Job Name: The Highlands

Re: The Highlands – Final Plat DRB # 1010879

Enclosed for Development Review Board (DRB) review and comment is a re-submittal of The Highlands Final Plat. Please see the responses to DRB comments (dated 05/03/17) below:

P:\2017\1015\SURVEY\GHA\PLAT\052017\03_05_P1A1.dwg
Plotted: 21-Apr-2017 11:38:00 AM, Plotted by: AMANG

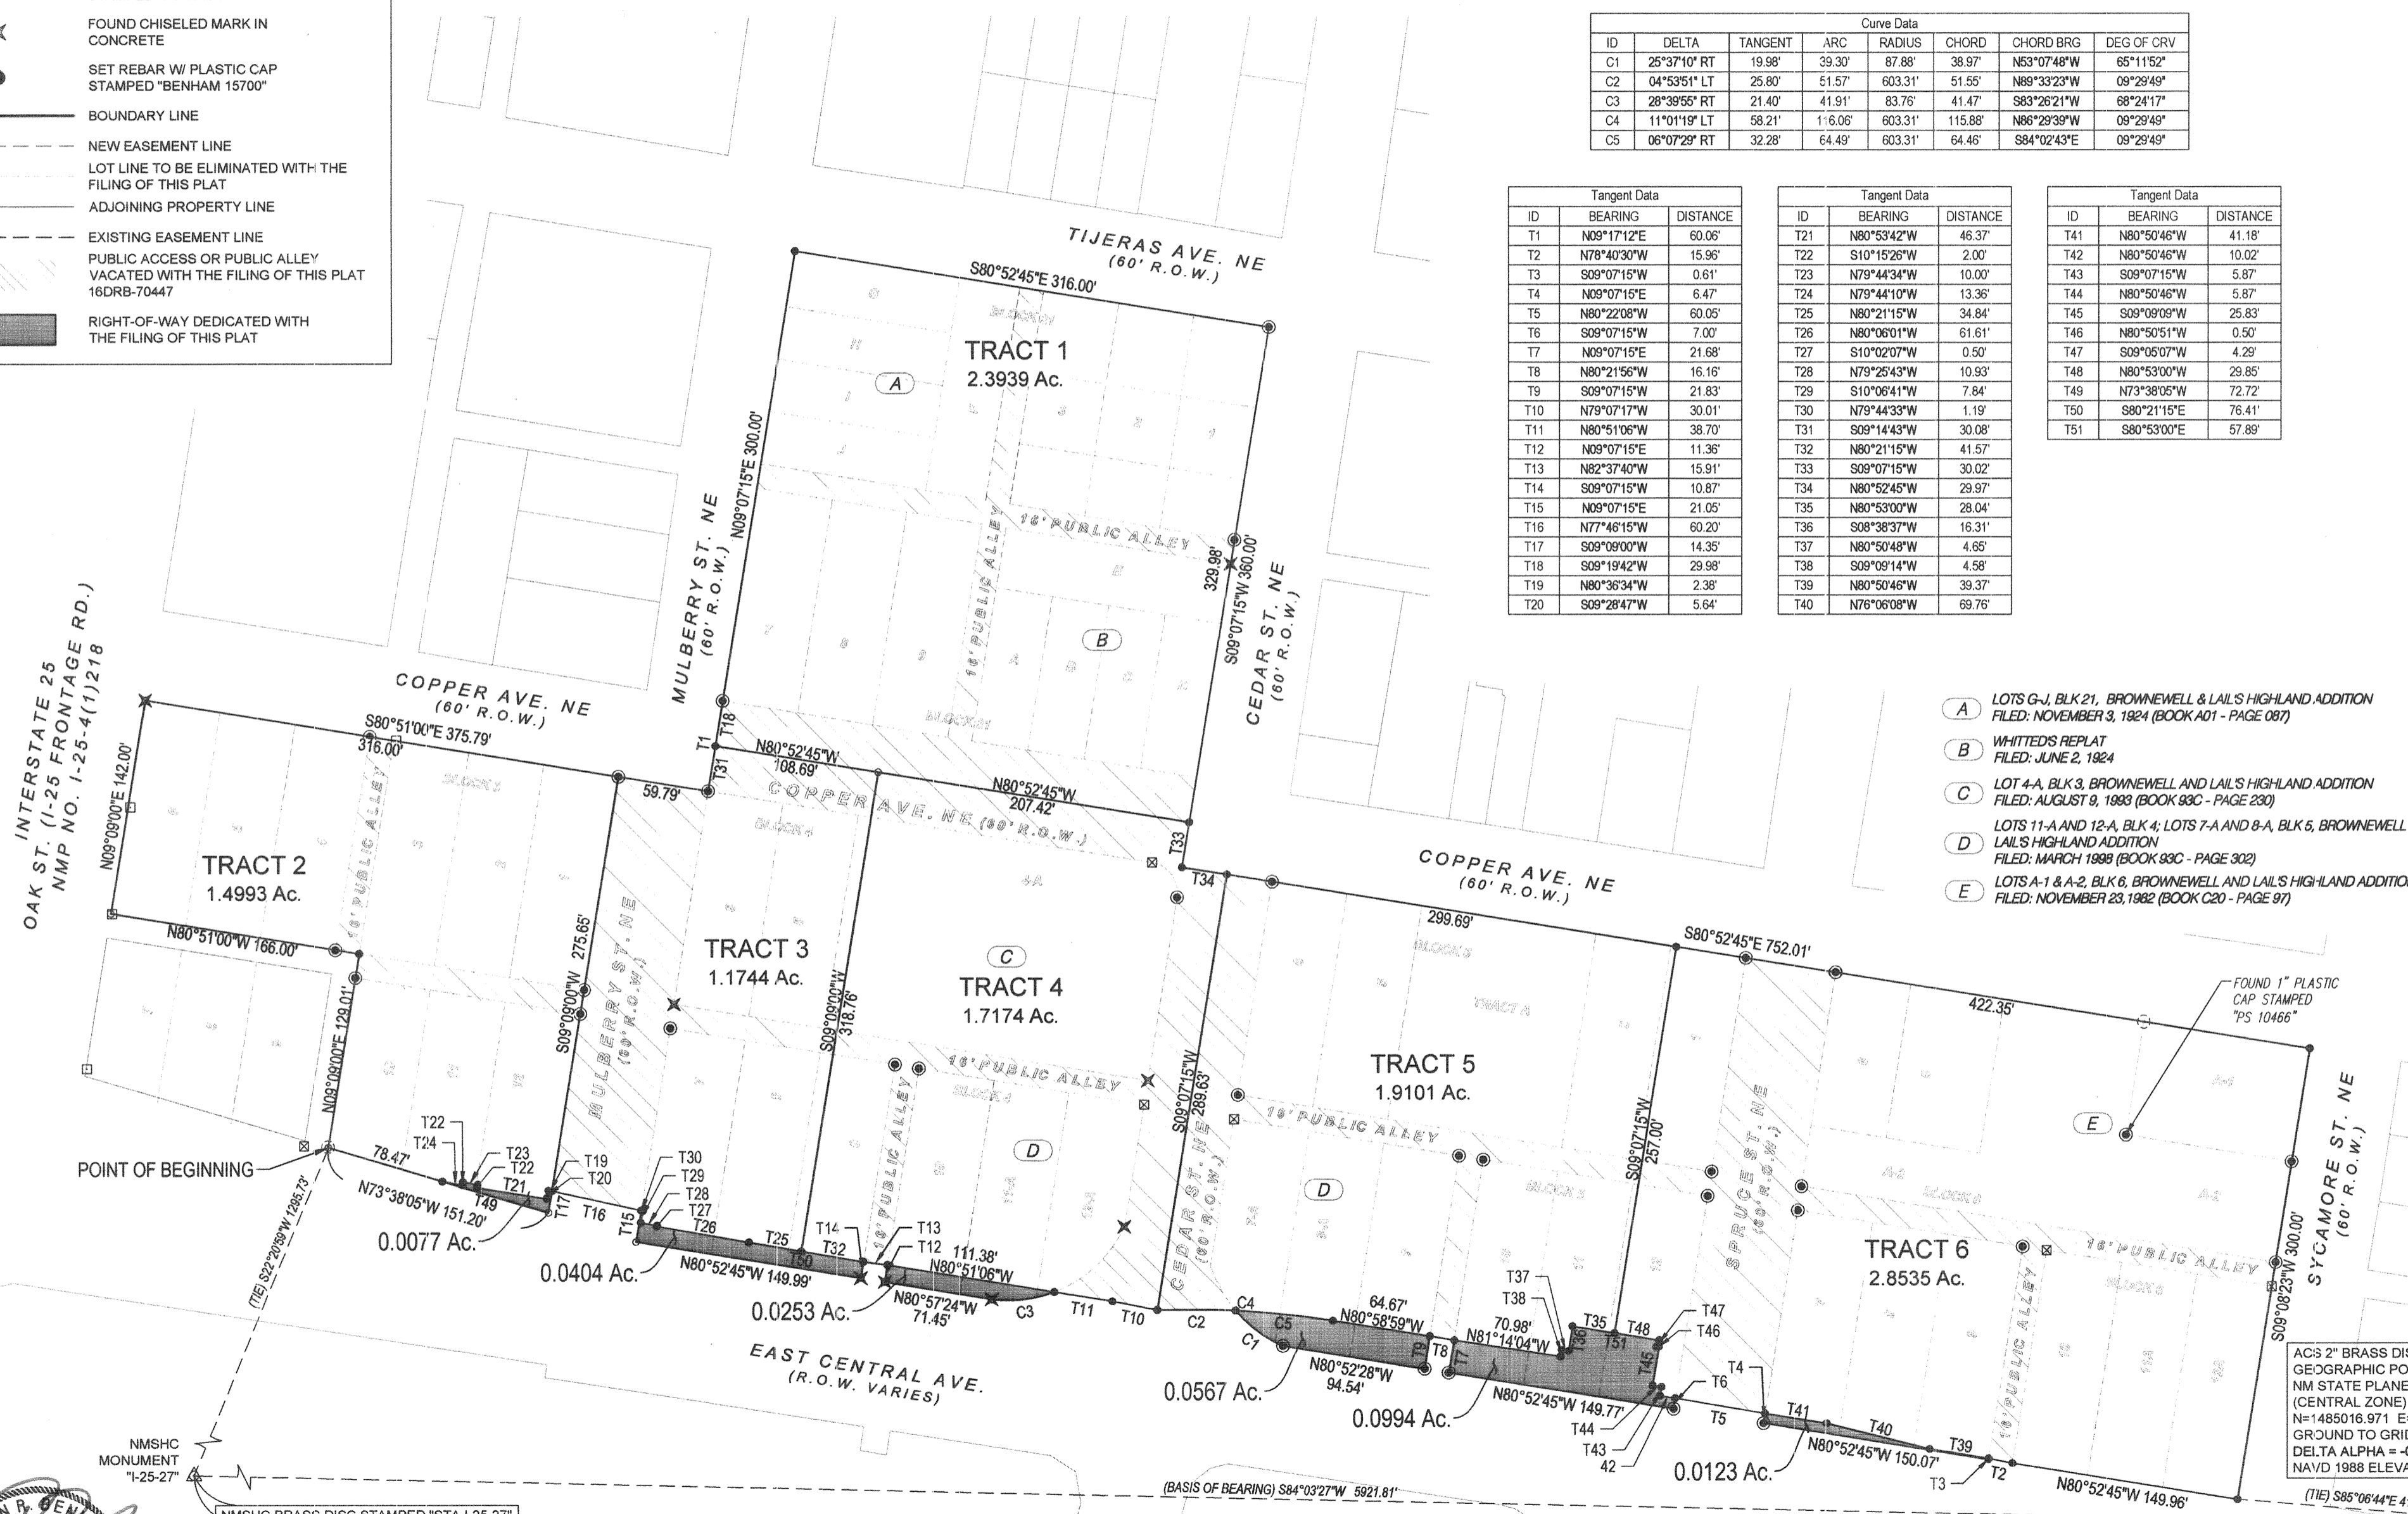
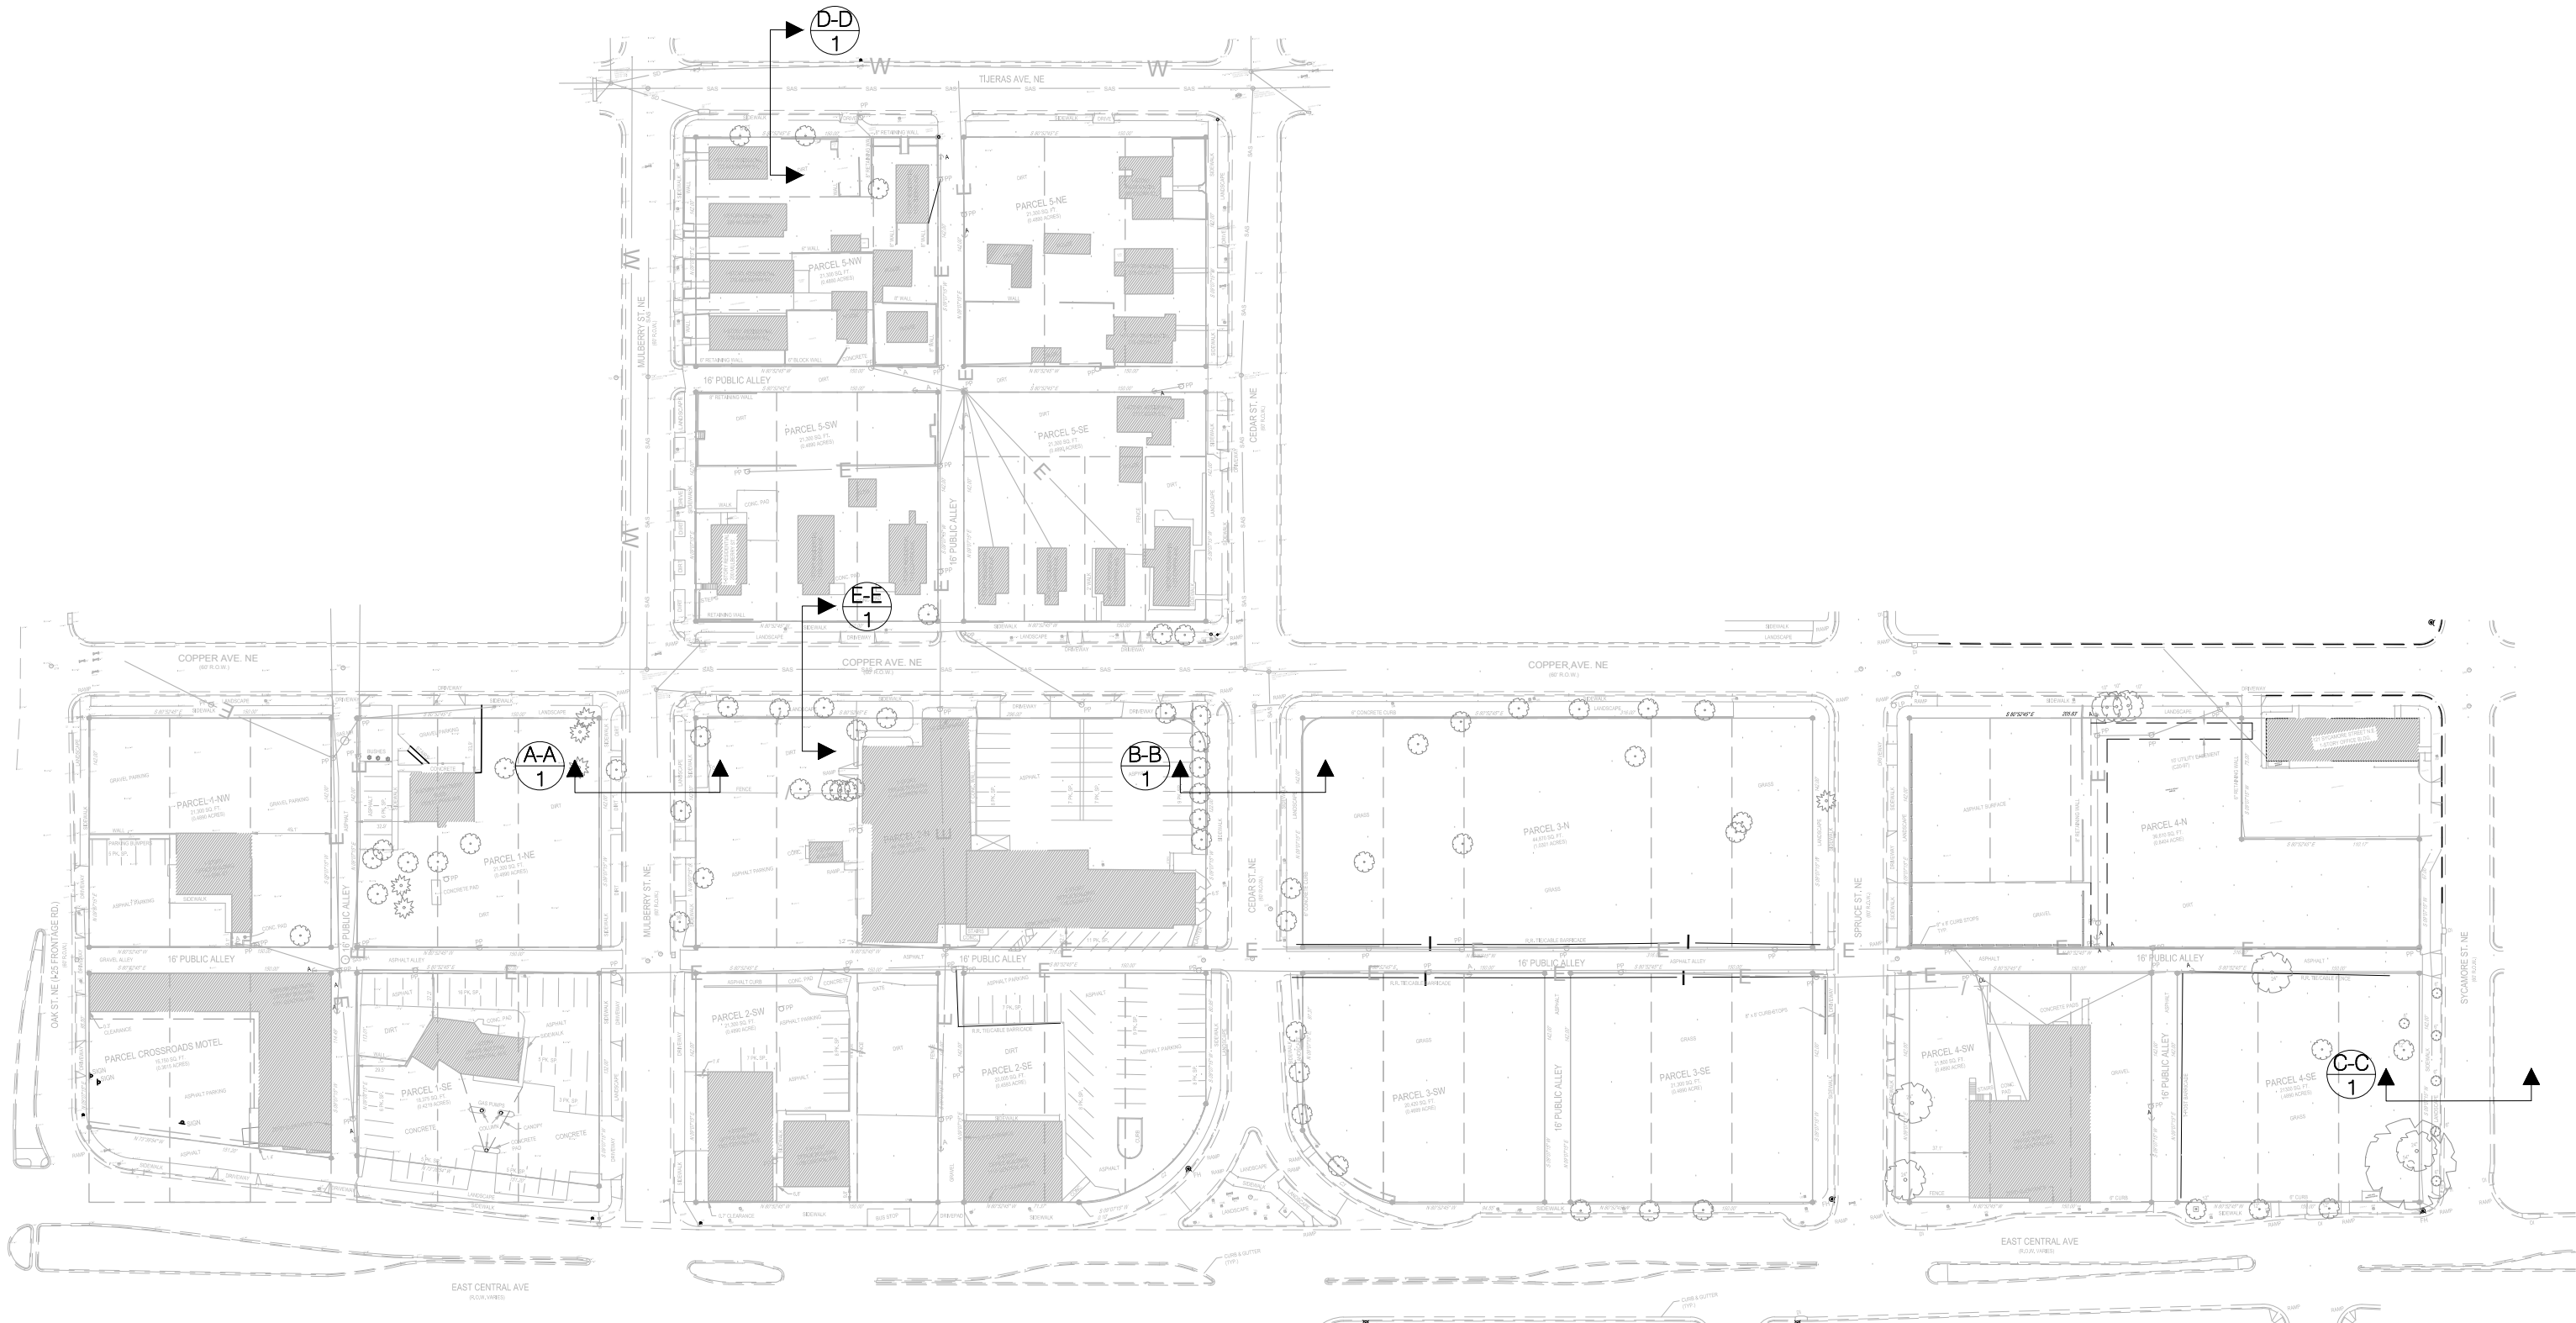
3. Copper Ave.: The proposed 60' public access & public drainage easement needs to include public waterline and public sanitary sewer as there is existing infrastructure along this corridor.

5. Alley: There is an existing 8" sanitary sewer along an existing alley (north/south) within proposed Tract 2. The proposed plat does not grant an easement for this sanitary sewer line.

Response: Noted. A proposed 60' water & sanitary sewer easement has been added to the plat. See sheet 3.

Response: An easement has been granted for this 8" sanitary sewer in the existing alley (north/south) within proposed Tract 2 on the plat. See sheet 3.
